LADACAN comments on Deadline 7 submissions IP ref 20040757

Table 1: LADACAN’s comments on the Applicant’s REP7-048 submission

Figure C1: London Luton Airport noise monitoring stations and radar tracks, 2019

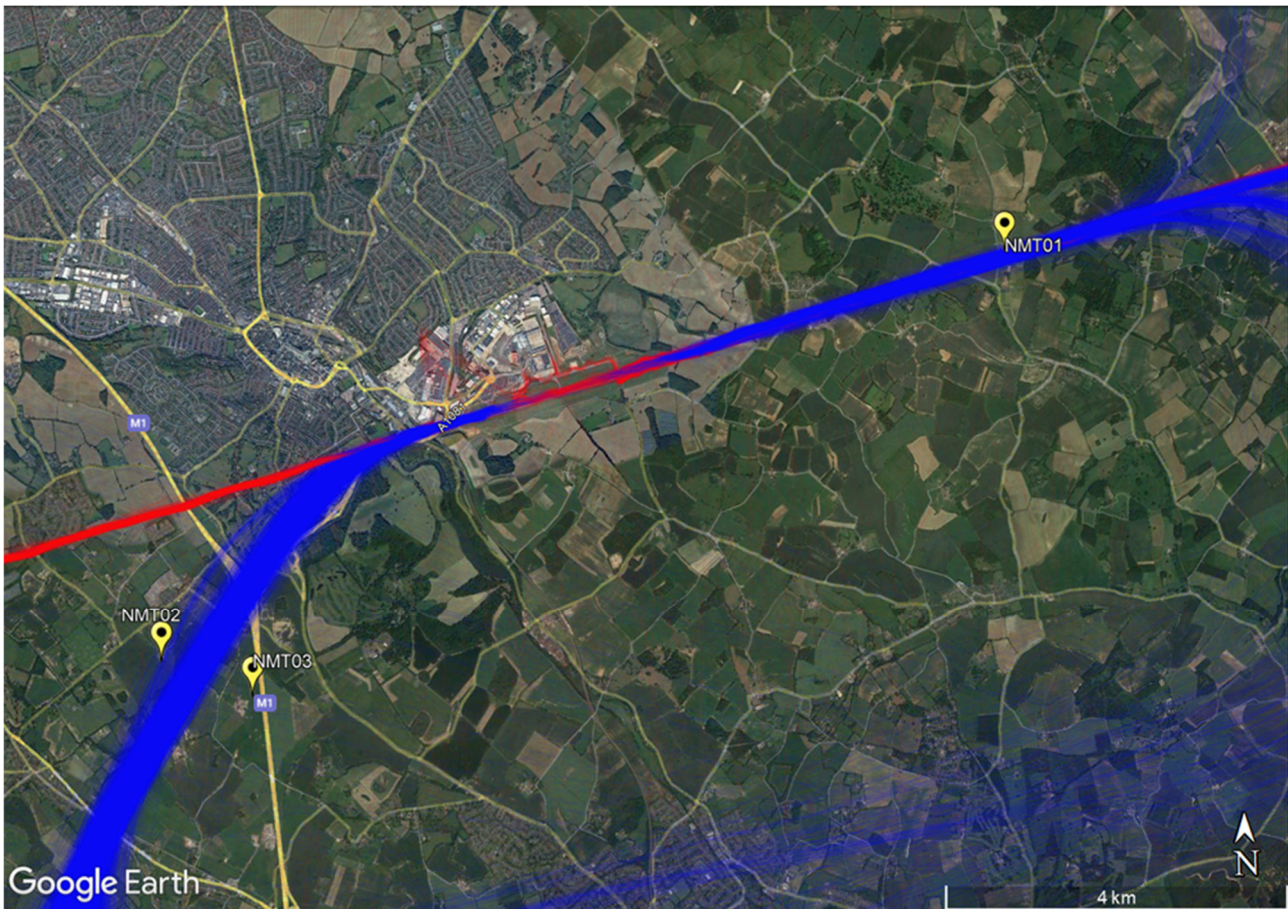
PINS ID	Question	Luton Rising's Response	LADACAN comments
GCG.2.8	<p>Explain whether any additional noise monitoring is being proposed over and above the basic monitoring that would be required to satisfy any future airspace change.</p> <p>Also clarify whether the quoted distances in paragraph C4.2.3 of Appendix C Aircraft Noise Monitoring Plan [REP5-028] should be 6.5 kilometres (km) from start of roll and 2km (our emphasis) from the landing threshold, rather than 2.5km? It is understood that the International Civil Aviation Organisation (ICAO) requirement of 2.5km relates to light aircraft.</p>		<p>For the assistance of the ExA, the LLA Noise and Track Sub-Committee has discussed the following:</p> <ol style="list-style-type: none"> 1) The need for a fixed noise monitor to cover runway 07 arrivals (ie somewhere in Caddington, 6.5 km from start of runway 25 roll) 2) The need for a statutory noise monitor positioned between NMT02 and NMT03 (ie located directly beneath the flight path, rather than the existing noise 'gate' where NMT03 is too close to the M1) 3) The benefit (as the Applicant has noted) of monitors somewhere roughly 2km outward from each end of the runway to assist in noise model validation in respect of departure profiles. <p>LLAOL has undertaken to consider these proposals.</p> <p>It would be helpful for a firmer commitment to be made as part of the Examination of this Application.</p>
